STATE HIGHWAY 105 / JACKSON CREEK PARKWAY - PHASE 2

CONSTRUCTION PLANS

FEBRUARY 2023

Comments provided by DPW Development Services

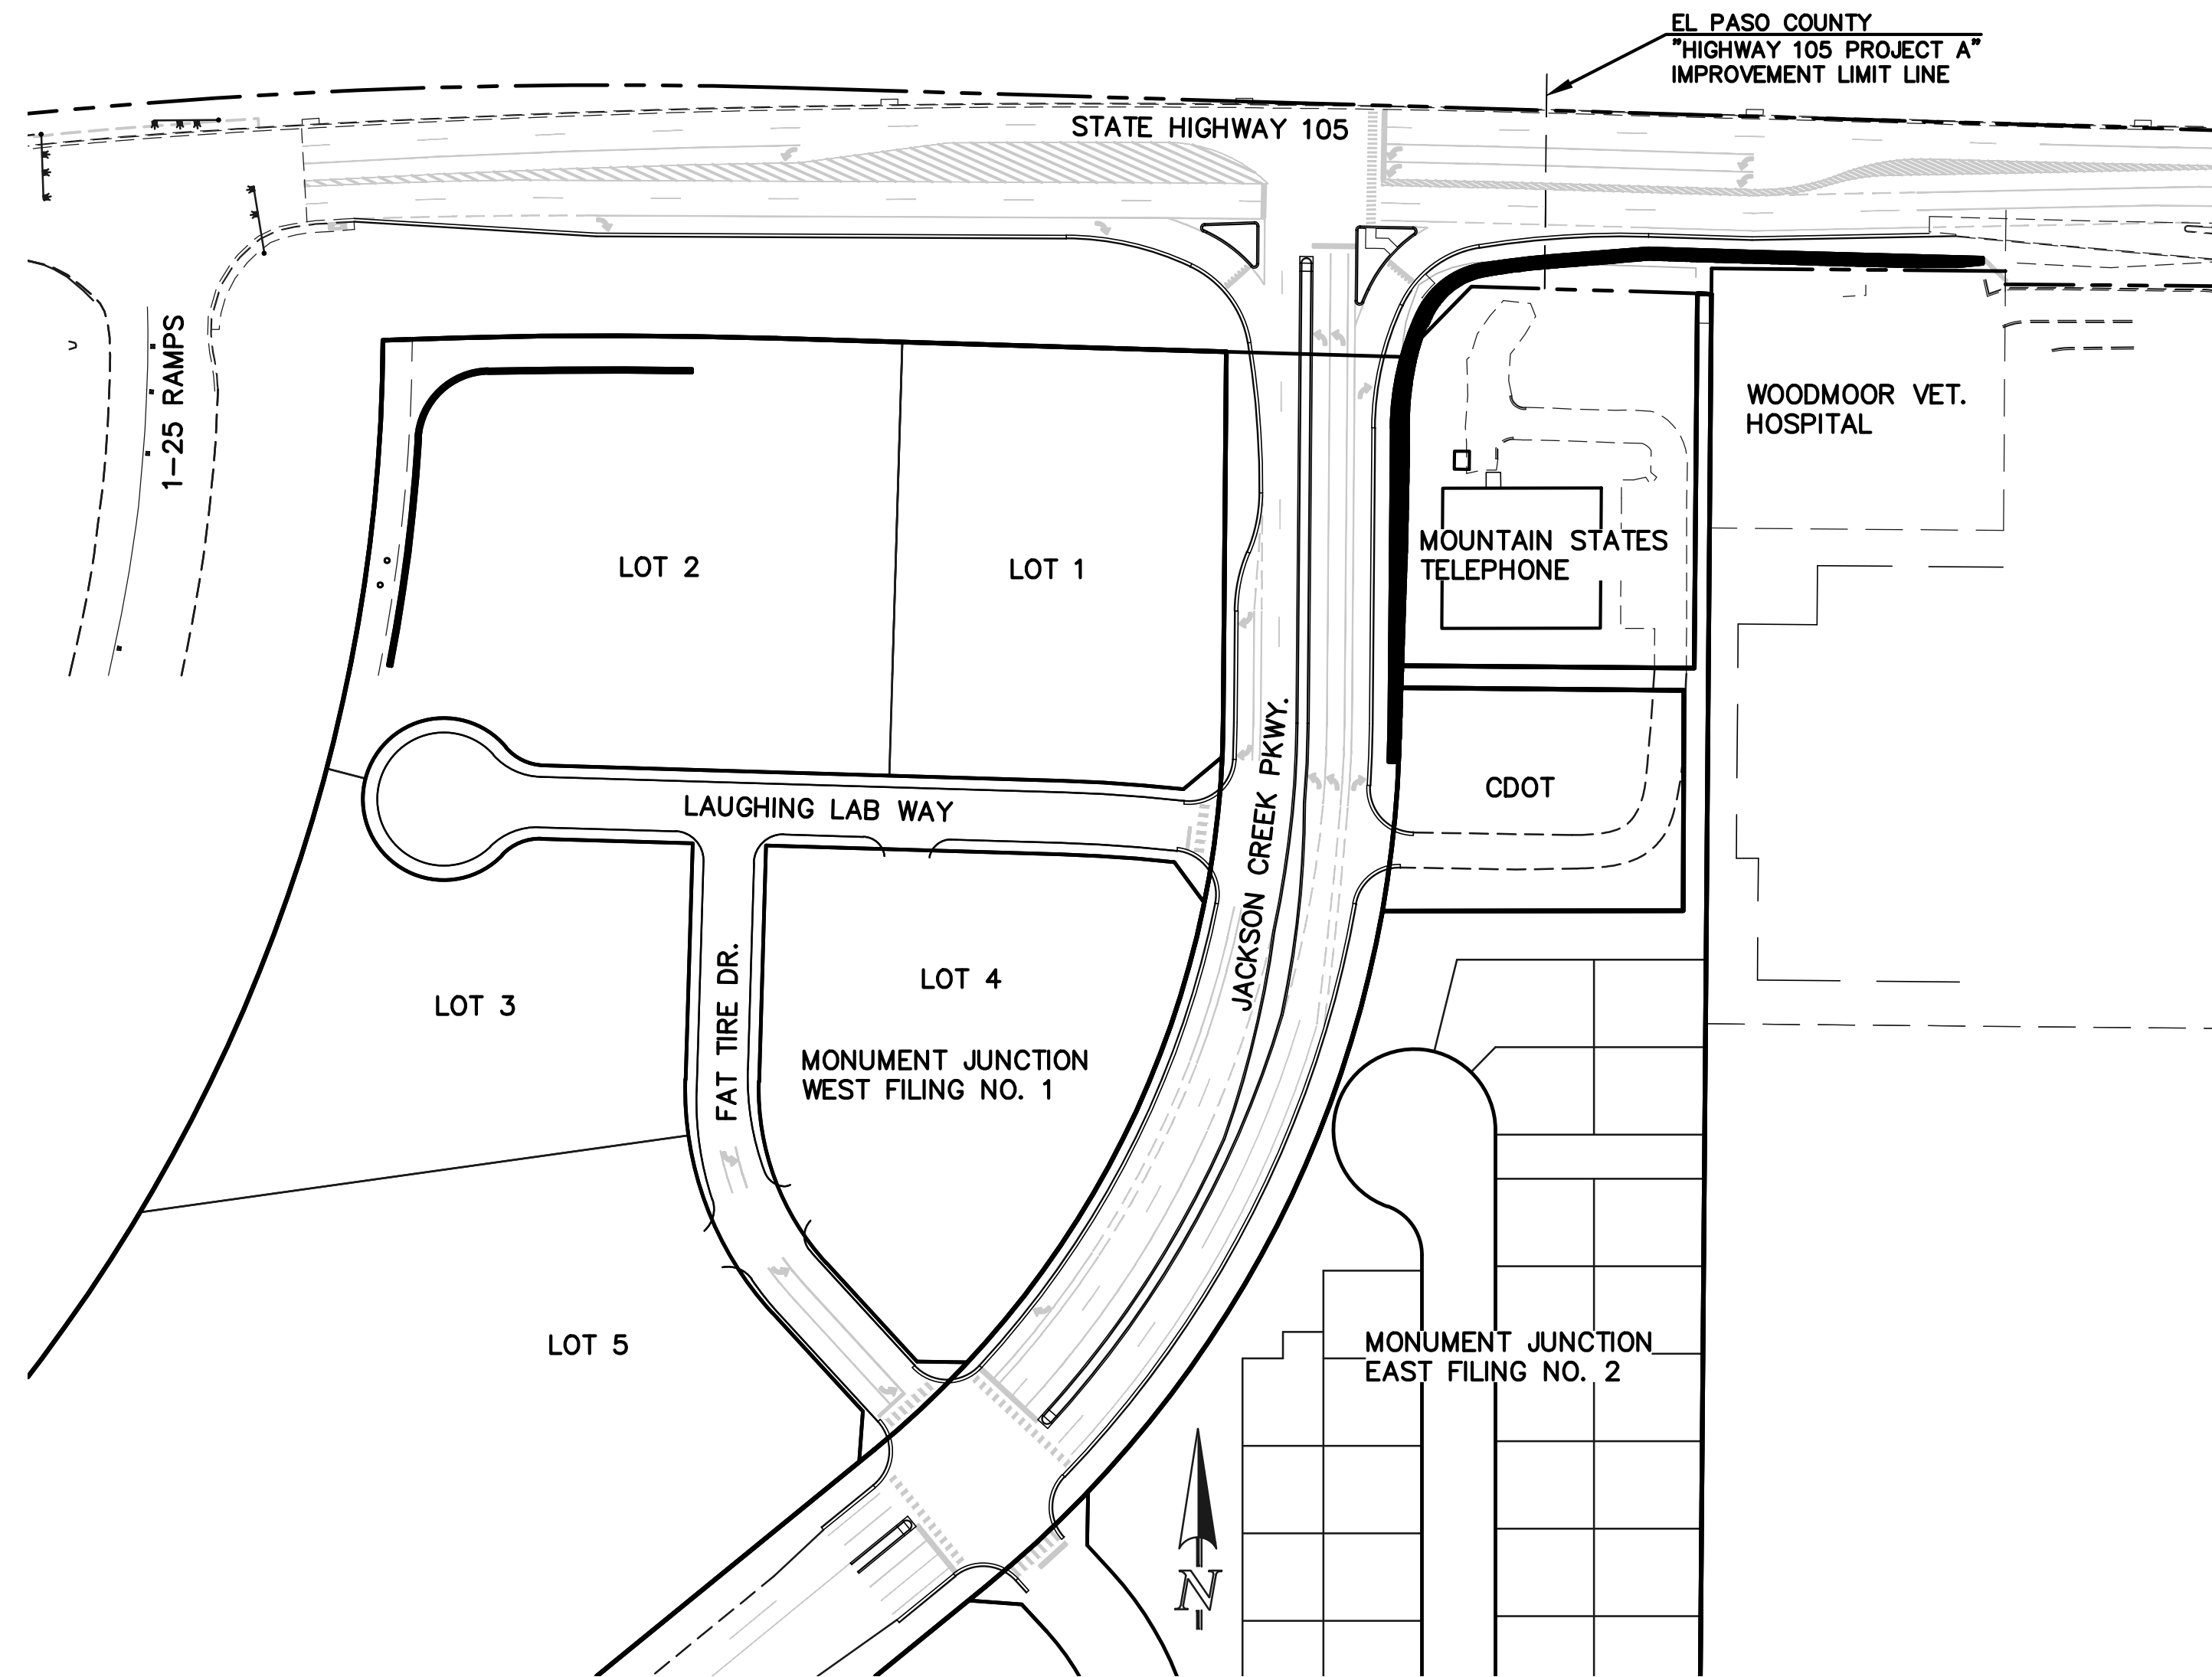
Since this construction drawings encompasses multiple jurisdictions Staff recommends Showing/Labeling the jurisdictional boundaries and extents of improvements each jurisdiction is approving.

Change dimensions to 24" & 8' Reference reference to CDOT detail.
